WILLOWTREE PLANNING

REF: WTJ21 - 285

RE: RESPONSE TO SUBMISSIONS - PROPOSED SECTION 4.55(1A) MODIFICATION APPLICATION - SSD 9522 (MOD 2)

PROPERTY AT 657-769 MAMRE ROAD, KEMPS CREEK LOT 34 DP1118173, LOTS X & Y DP421633, LOT 1 DP 1018318 & LOT 22 DP258414)

DRAWING TITLE
Site Plan (Warehouse 6 & 8)

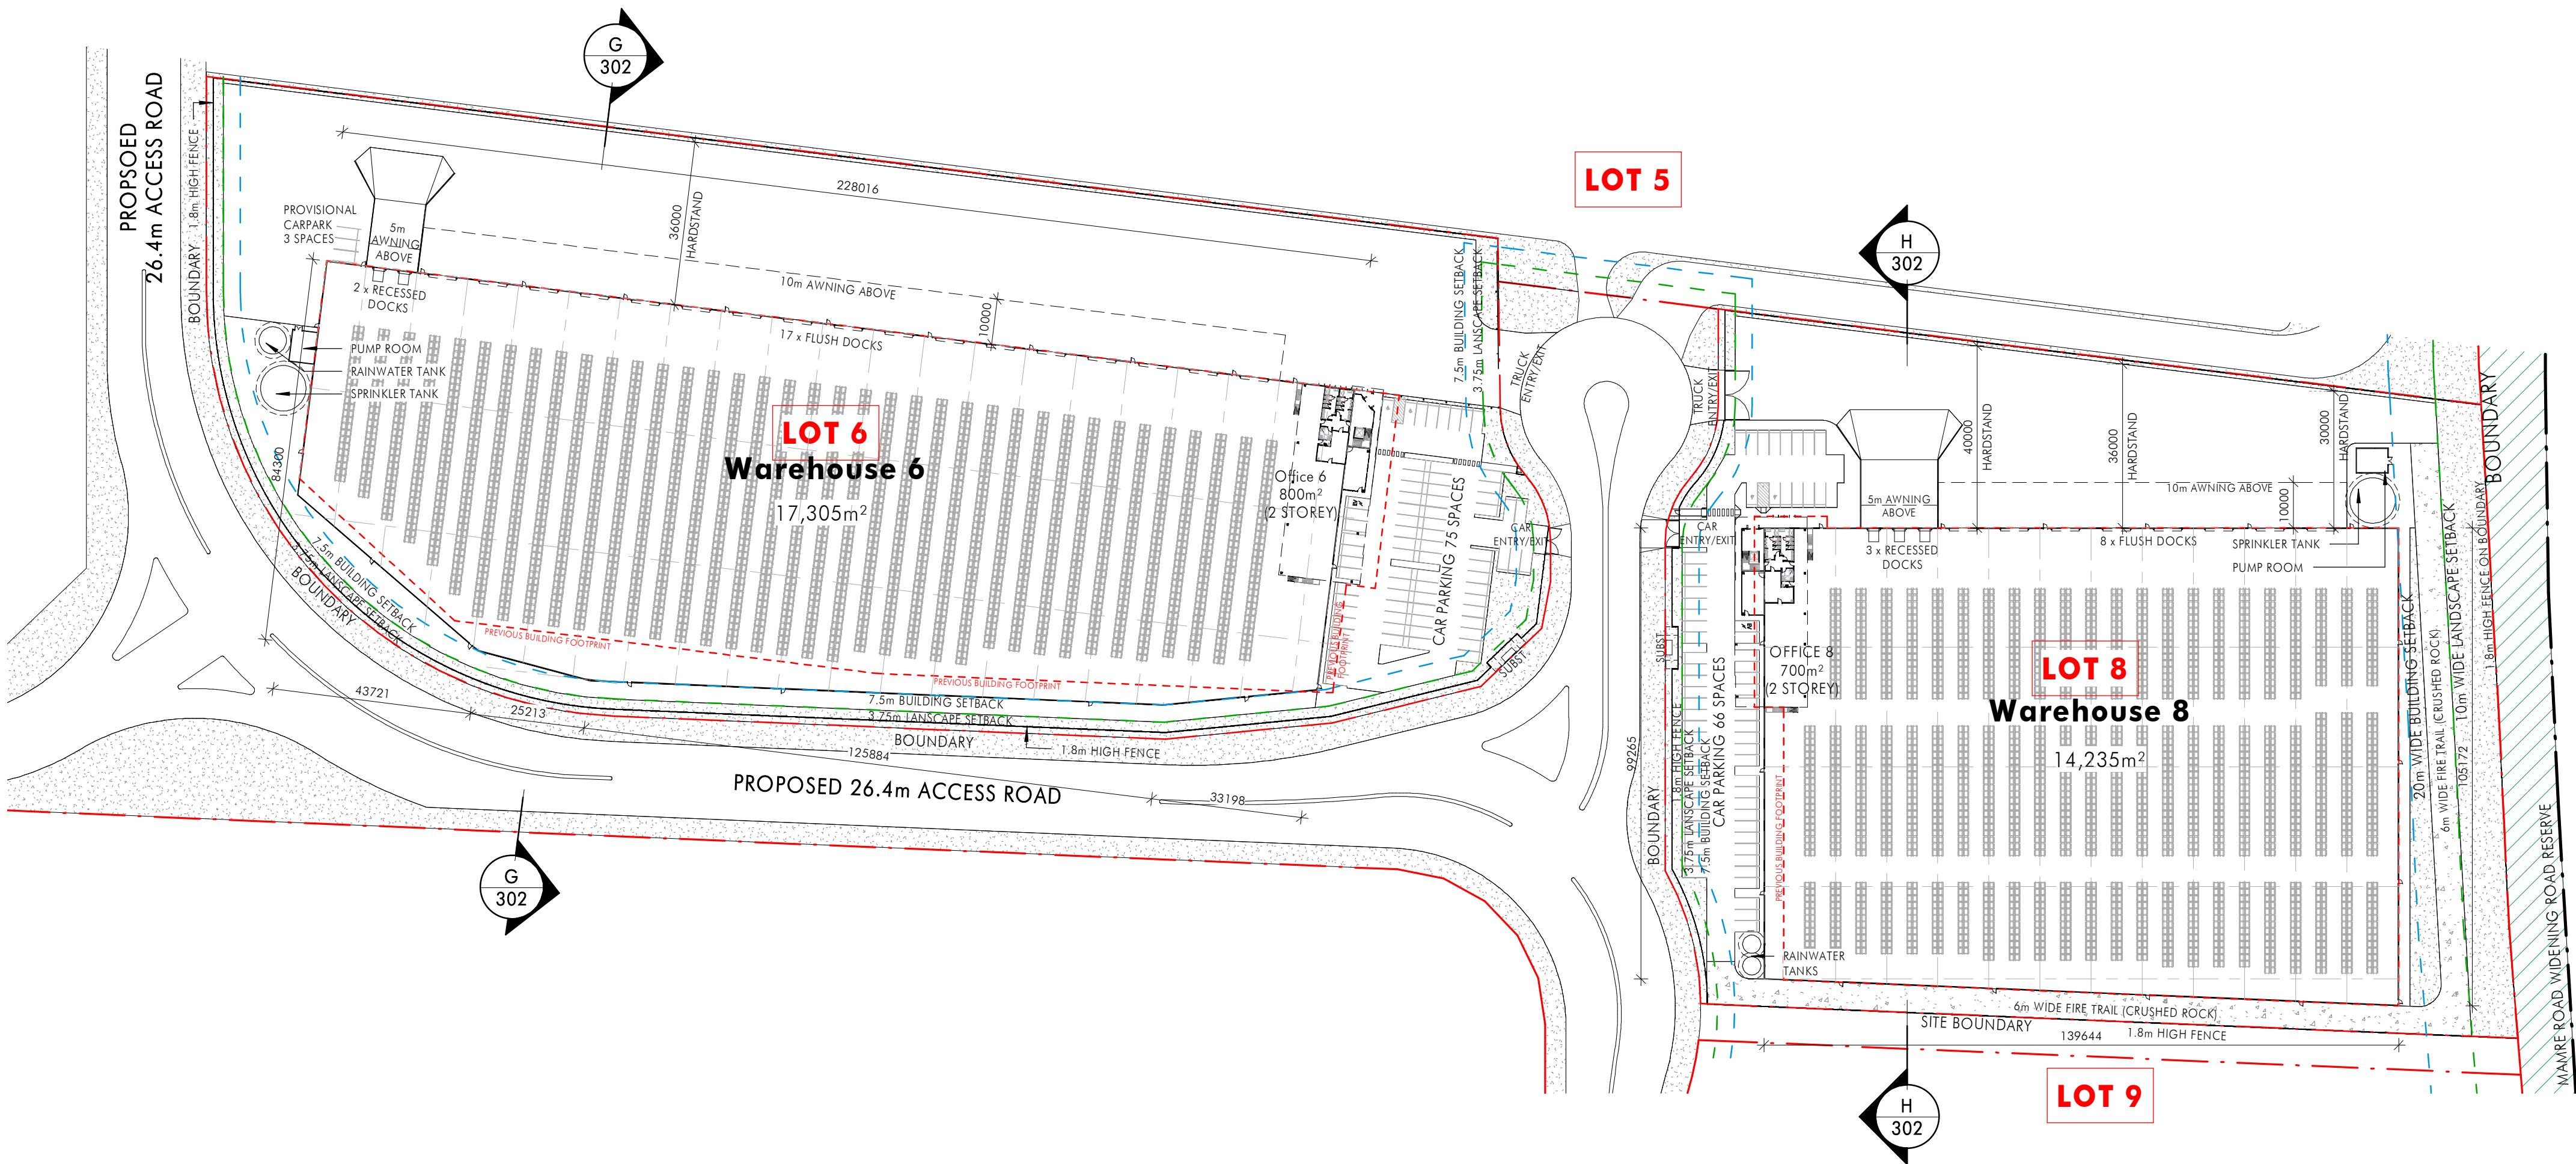
<p>(f) <u>Addition of car parking spaces</u></p> <p>Council does not support the proposed addition of five car spaces within the entry driveway to Lot 6.</p> <p>Council does not support any encroachments into the already reduced (4m to 3.75m under MOD 1) landscaped setback to Estate Roads.</p>	<p>The proposed additional parking is consistent with the Mamre Road Precinct DCP and site-specific DCP car parking requirements, as well as AS2890.1 and will not result in any additional traffic or parking impacts, as described in the submitted Traffic Report.</p> <p>Where appropriate, landscaped setbacks in excess of the requirements have been provided to compensate for any minor carpark intrusion into the landscape setbacks required by road curves. The overall quantum of landscaping is increased.</p>
<p>(g) <u>Landscaped blisters</u></p> <p>Landscaping must be provided in accordance with the requirements of the Mamre Road Precinct DCP. It is requested that landscaped setbacks be increased to comply with the MRP DCP.</p> <p><i>As per the requirements of the MRP DCP, tree planting in the form of island planter beds shall be provided at a rate of one planter bed per 10 car spaces (preference is 1 every 6 spaces) within car parks to reduce the heat island effect of hard surfaces that are a minimum 1.5m wide</i></p>	<p>The approved development is subject to the site-specific DCP and the controls contained in the Mamre Road Precinct DCP are not relevant to the subject modification application or approved development.</p> <p>The approved development is subject to the site-specific DCP and the controls contained in the Mamre Road Precinct DCP are not relevant to the subject modification application or approved development.</p>
